**From:** Colin King [REDACTED] >  
**Sent:** 30 July 2020 22:05  
**To:** Norfolk Boreas <[NorfolkBoreas@planninginspectorate.gov.uk](mailto:NorfolkBoreas@planninginspectorate.gov.uk)>  
**Subject:** Norfolk Boreas EN10087

These are the questions I put to the applicant at the Open Floor Hearing:

Noise receptor locations
(Map 9 of 9)

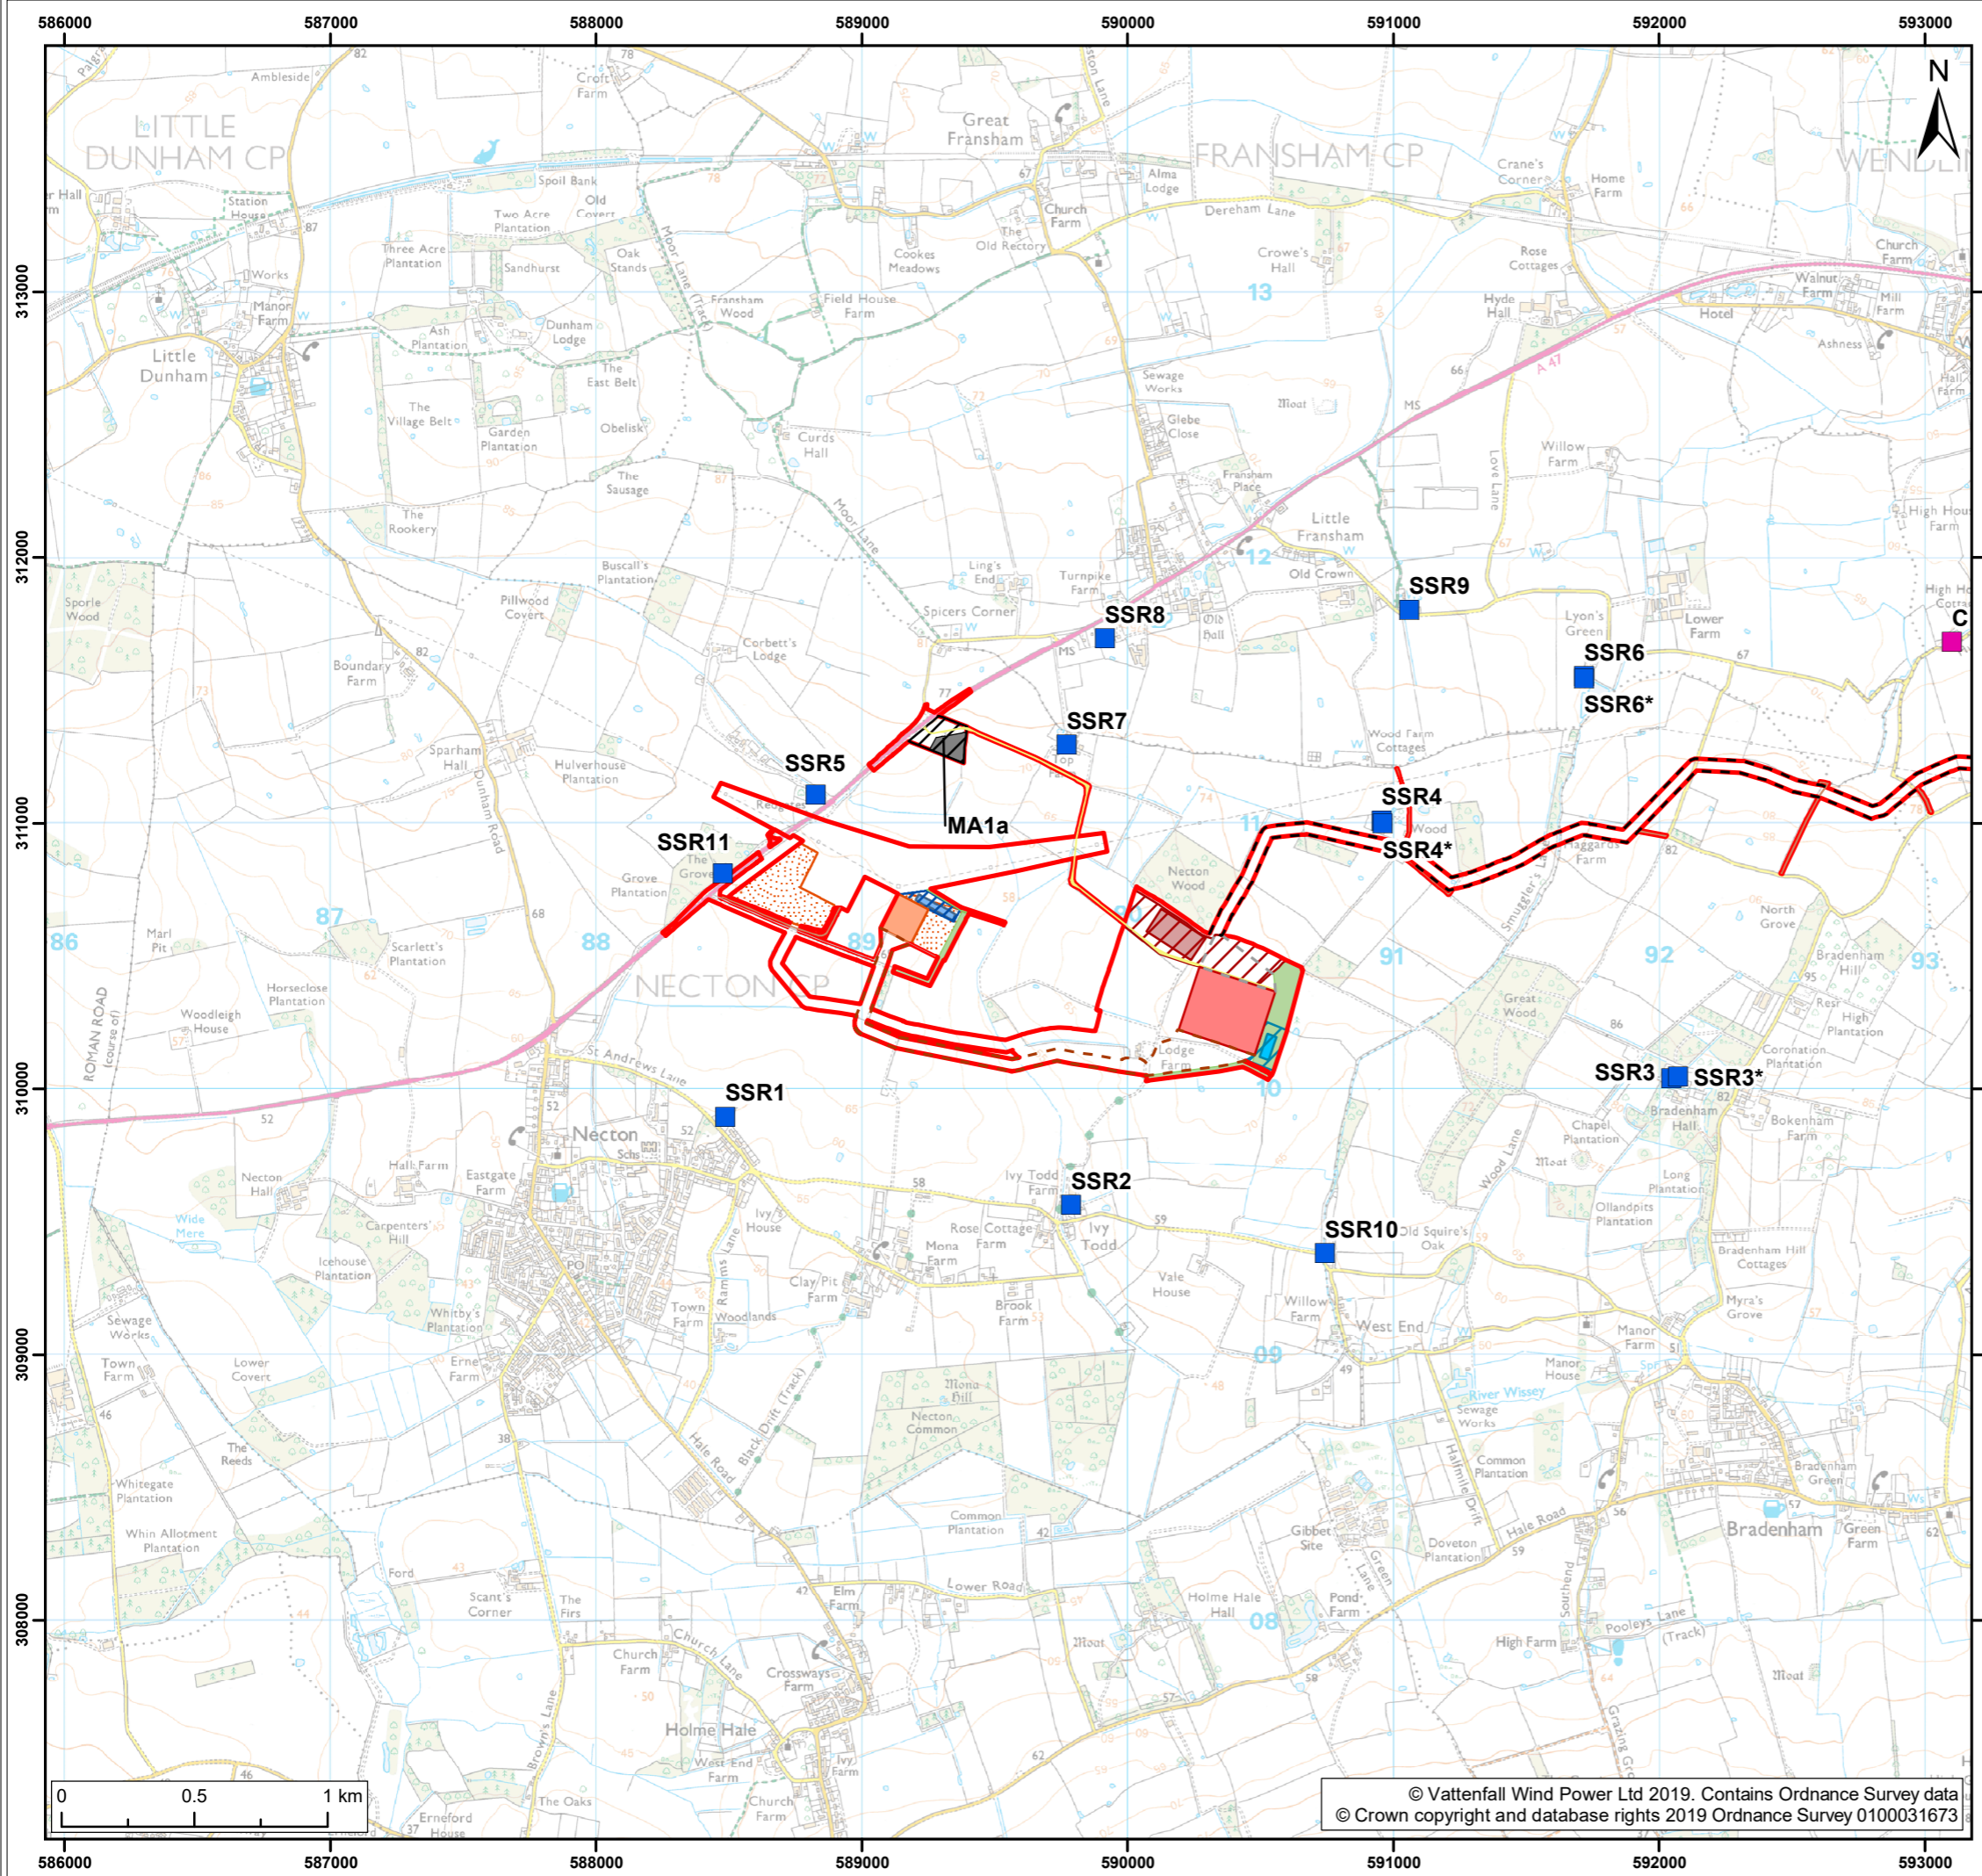
1. Why do you consider it acceptable to use a noise limit 6.6dB 5mins and 3.6dB 15mins, over the average background noise level?
2. Why do you think it appropriate to use the same noise limit as Dudgeon, when Dudgeon's nearest sensitive receptor is next to the A47, and Vanguard's and Boreas's are in a quiet, tranquil area?

3. Why isn't there any adjustment in the sound sensitivity rating of residential properties, according to the existing character of the surrounding area, and residential properties are rated moderate regardless of whether they are near a main road, in a village, or in a quiet area?

4. Are you regarding Necton and the surrounding area as an industrial, commercial area, as you are using a noise limit greater than the measured background noise level, and only intending to partially screen a large industrial construction, in a rural area?

5. Is it acceptable to use data from only two long term sound monitoring points, and one measured for a day, out of the proposed 12?
